Martin Nugent
01254 828060
D3/11/0849

Drafted 30 December 2011

**Planning Application, Ribble Valley District
3/11/0849 Great Mitton Hall, Mitton Road, Mitton**

3758 - 9

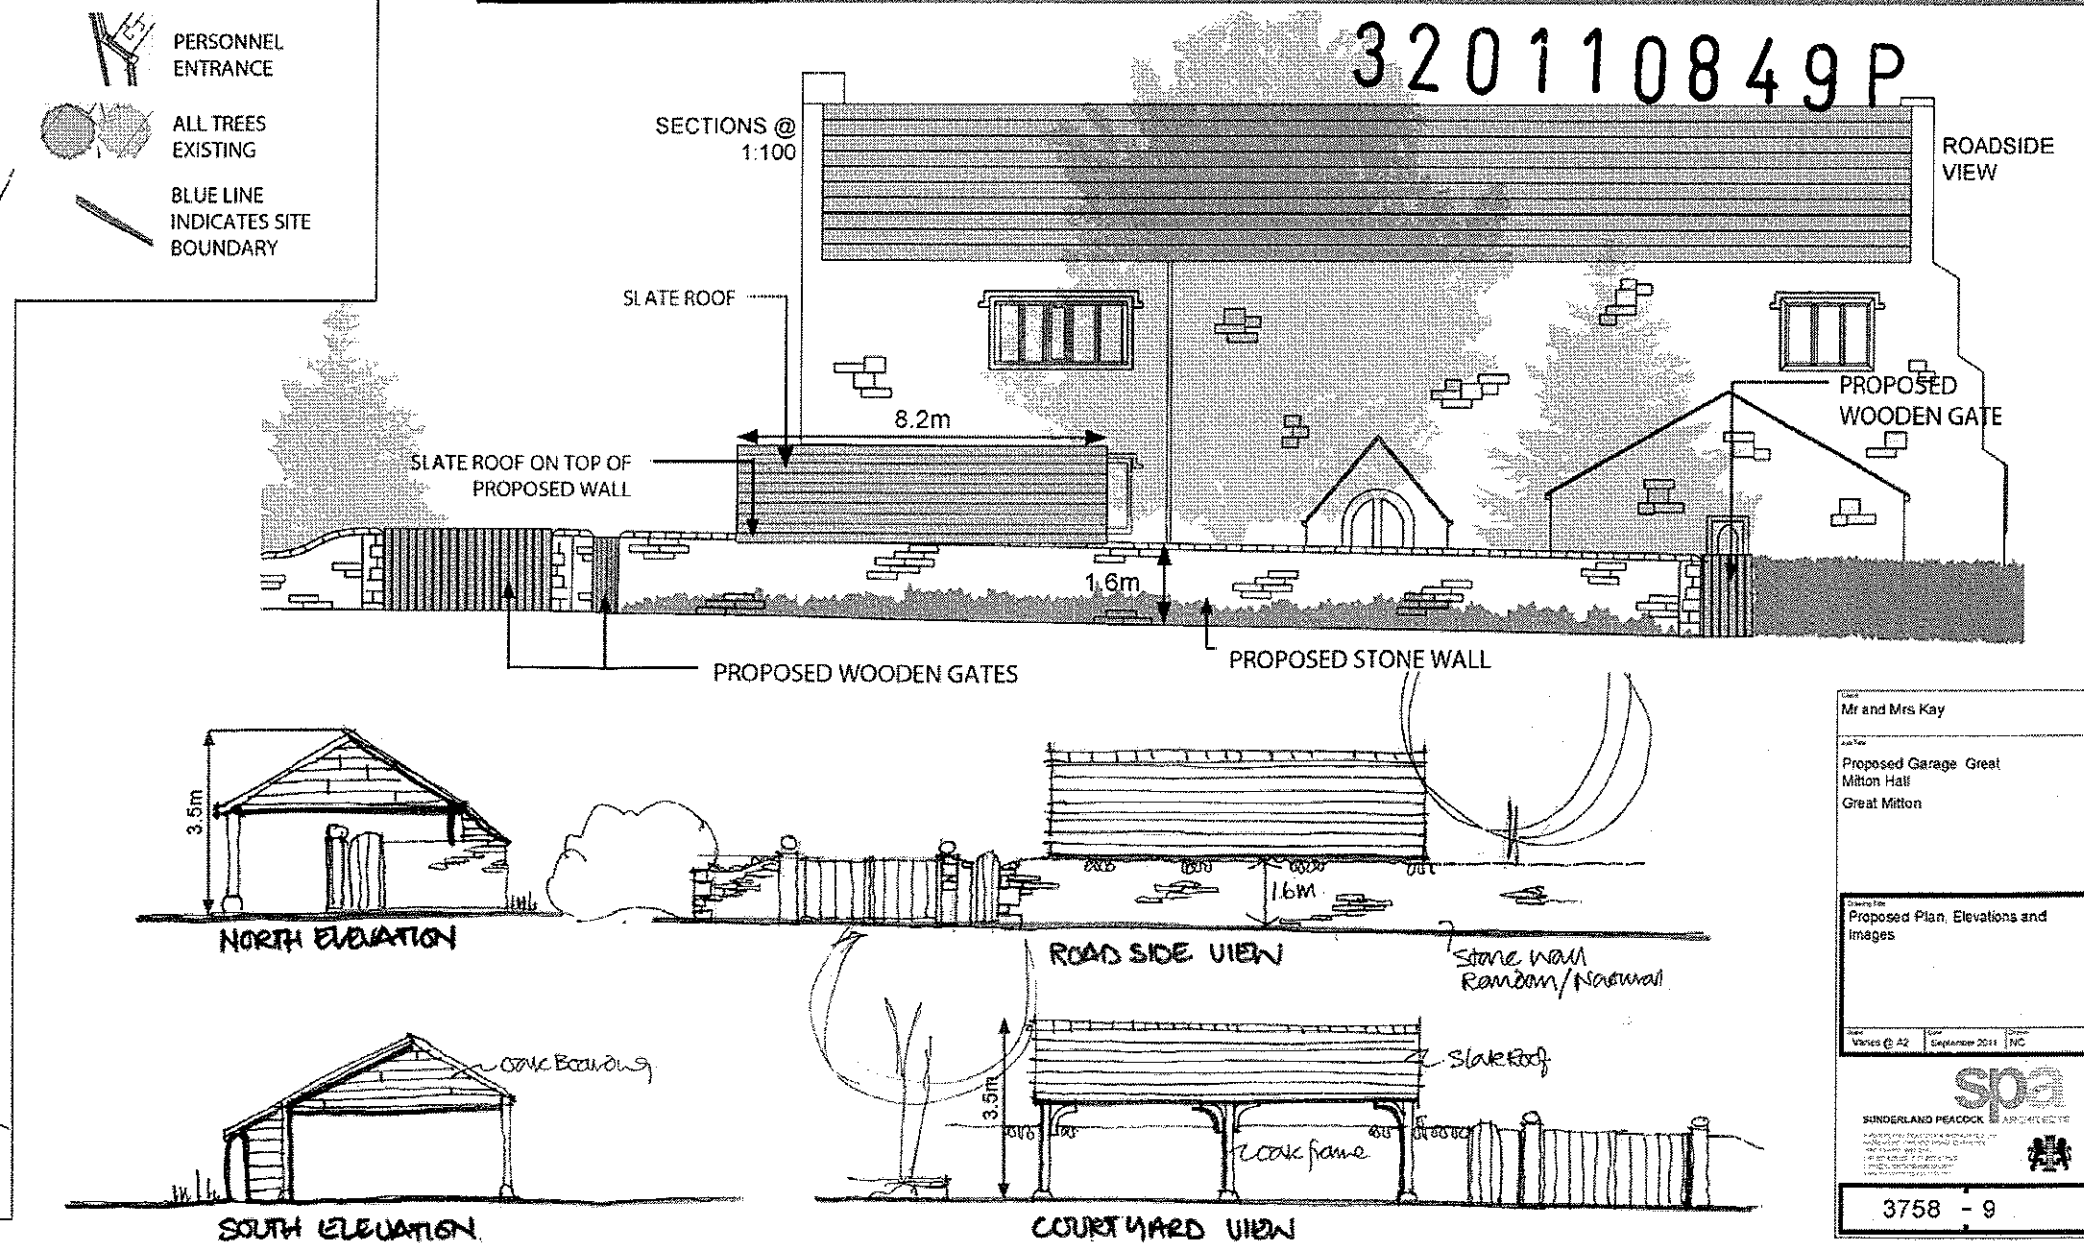
However, the introduction of a stone boundary wall as a replacement for the existing hedge provides a more prominent and permanently impermeable boundary along the frontage of the site.

In order to assist with visibility to the south, I would suggest setting the boundary wall back an additional 500mm from the back of carriageway for the length of the garage. In this way, visibility is improved for emerging motorists while the garage facility retains a depth of 5.8m. I would welcome the inclusion of the proposed alteration on an amended plan.
